03 May 2012

Our Ref: NW/RV/2012/28249/S

Application Number: 3/2012/0225
Site Address: Dewhurst Road Langho BB 8AF
Proposal: Proposed all-weather pitch with associated works

DRAWING TITLE	LAYOUT PLAN PROPOSED FLOODLIT SYNTHETIC TURF PITCH
---------------	---

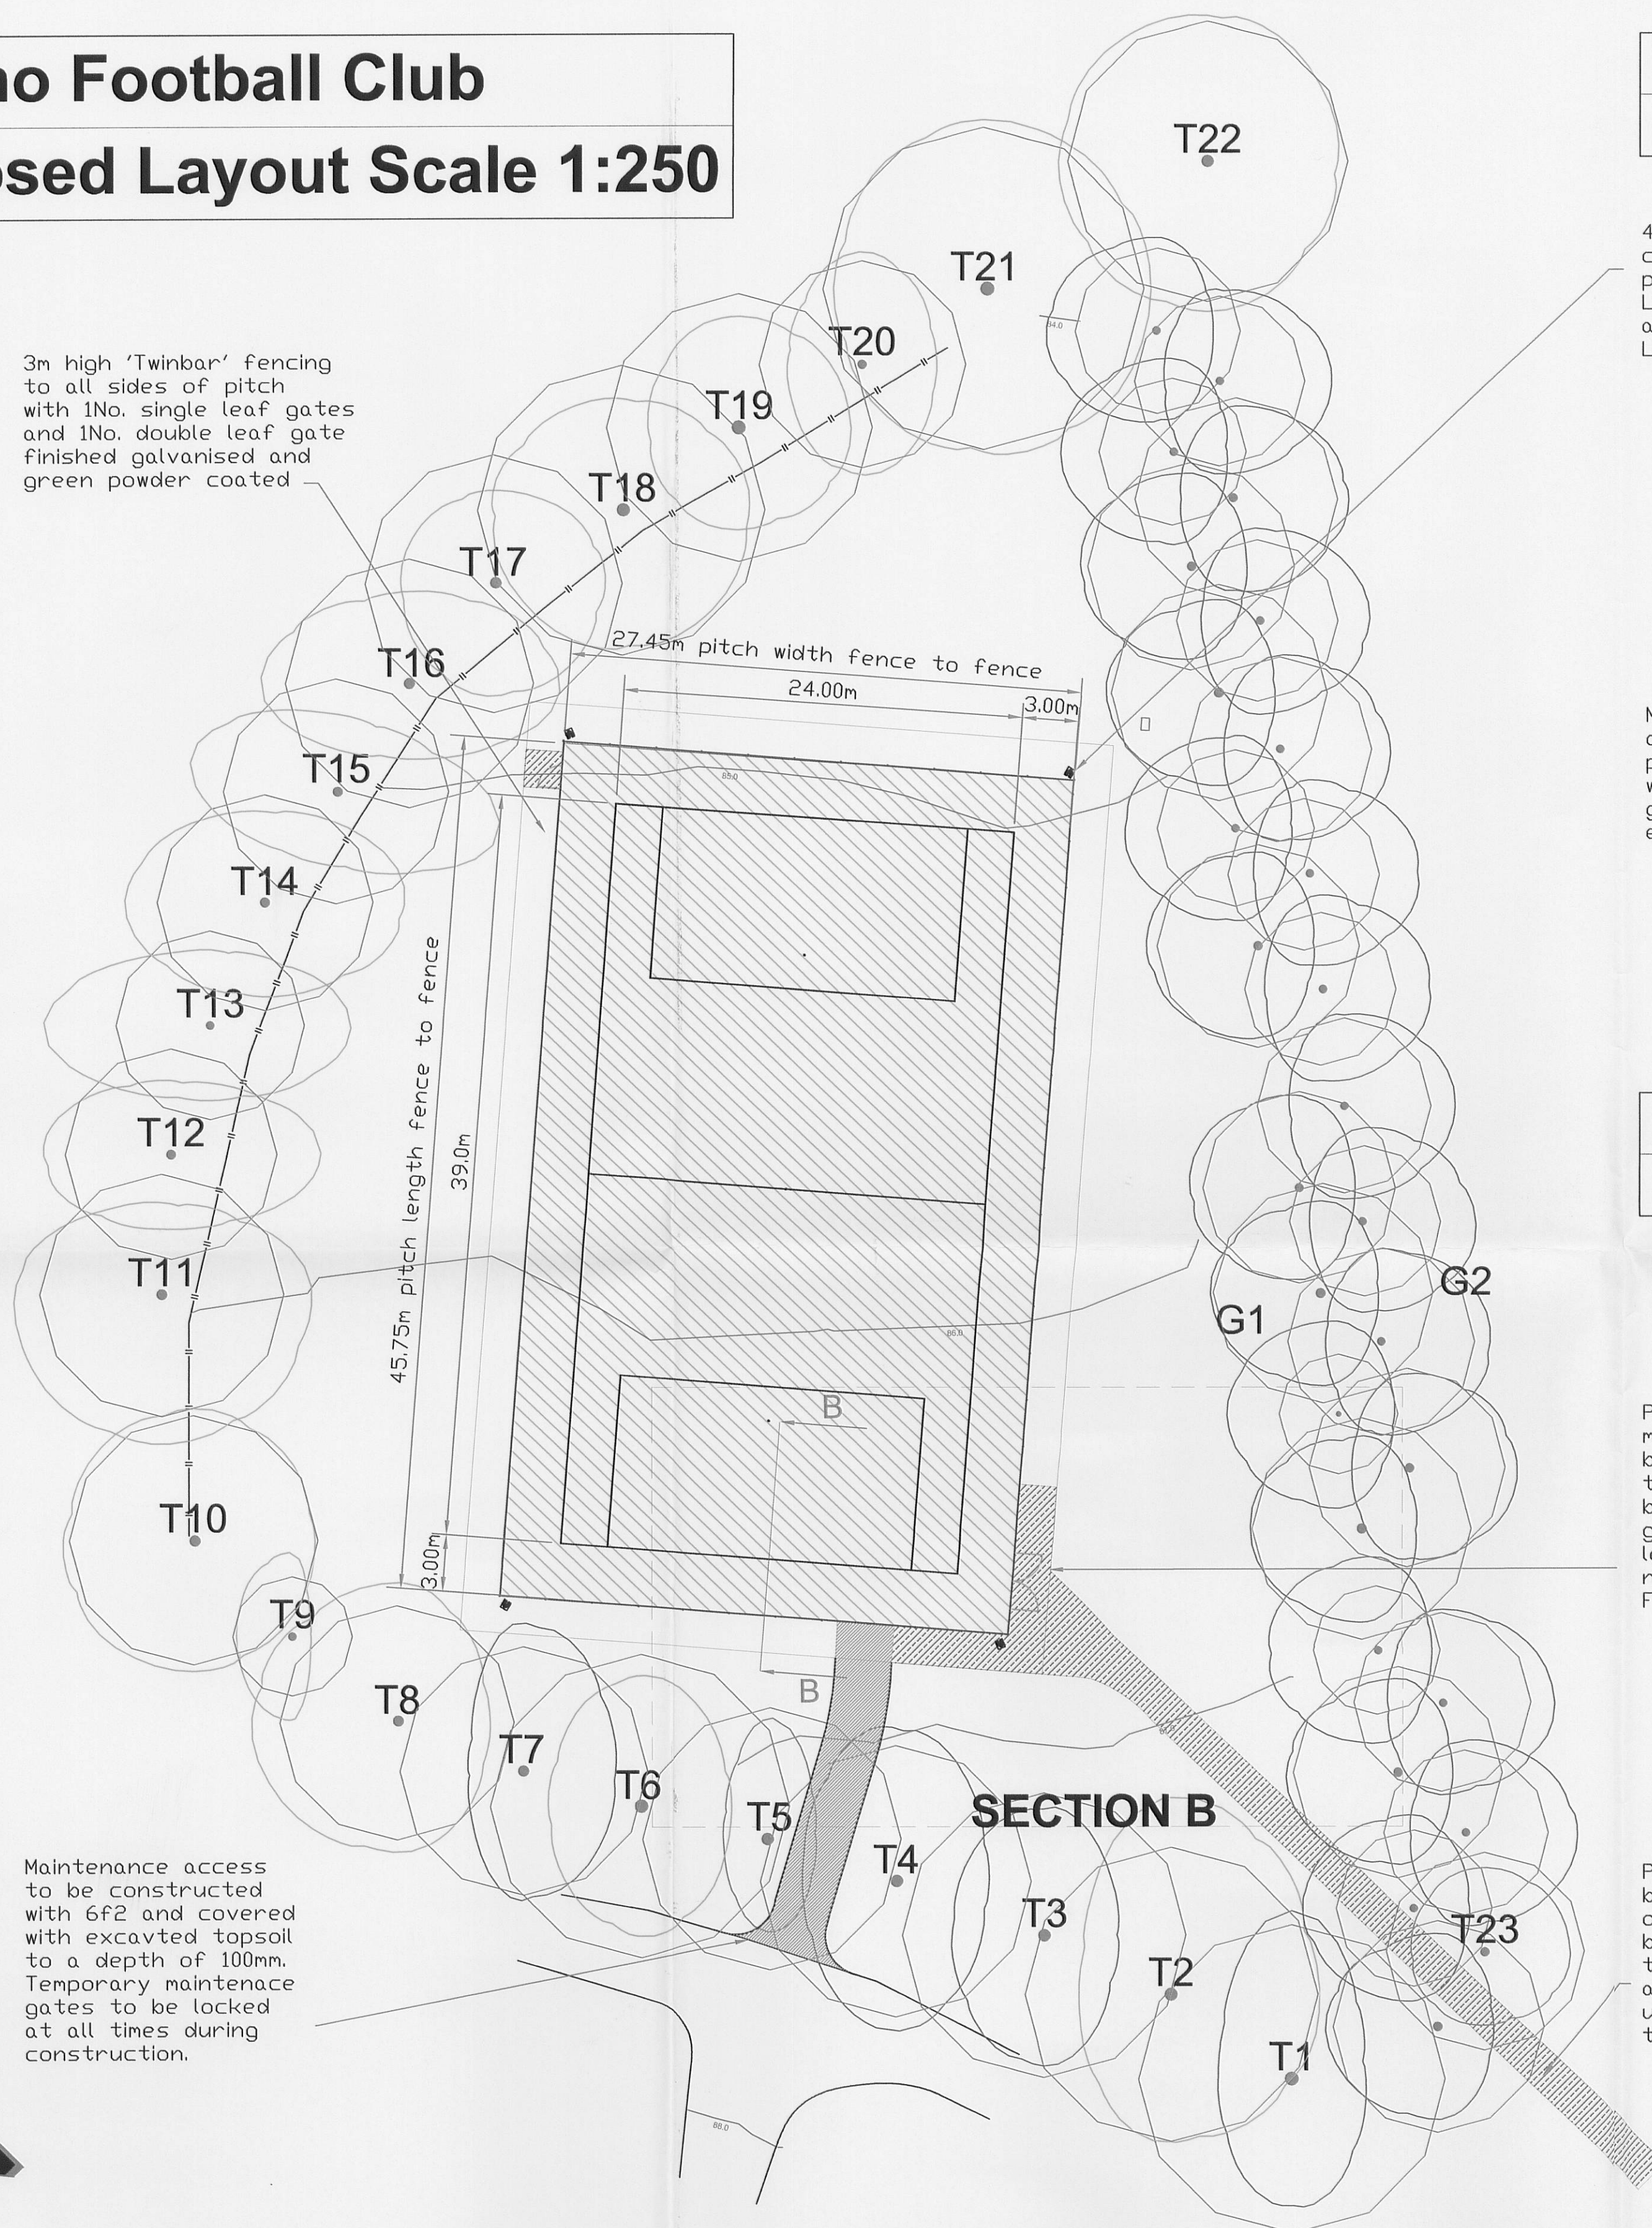
The proposal is for a floodlit Artificial Grass Pitch (AGP) on an area of amenity grassland immediately adjacent to and to the west of the existing pitches and clubhouse. The AGP will be for football use and is likely to be a 60mm 3G rubber crumb construction measuring 45.75m x 27.45m. This is a small size AGP and can accommodate under 6/7 age groups. The club has a large junior section and although a larger AGP would be preferable it will still meet the junior match and training requirements of the club.

Unfortunately, it is not possible to increase the size of the AGP due to the proximity of trees surrounding the site. However, a slight change in the design to include recessed goals may provide a slightly larger playing surface without increasing the footprint of the AGP. This design change was agreed with Ribble Valleys Tree Officer as the recessed goals will be located well away from the root protection zone.

However, as no technical design details of the AGP, only the footprint of the AGP has been provided Sport England will require the following condition be attached to any planning approval to ensure the facility is fit for purpose and sustainable:

No development shall commence until details of the design and layout of the Artificial Grass Pitch have been submitted to and approved in writing by the Local Planning Authority, after consultation with Sport England. The Artificial Grass Pitch shall not be constructed other than in accordance with the approved details.

Informative: The applicant is advised that the design and layout of the Artificial Grass Pitch should comply with the relevant industry Technical Design Guidance, including guidance published by the National Governing Bodys for Football, the Football Association. Particular attention is drawn to: 'Artificial Grass Pitches' published by the Football Foundation
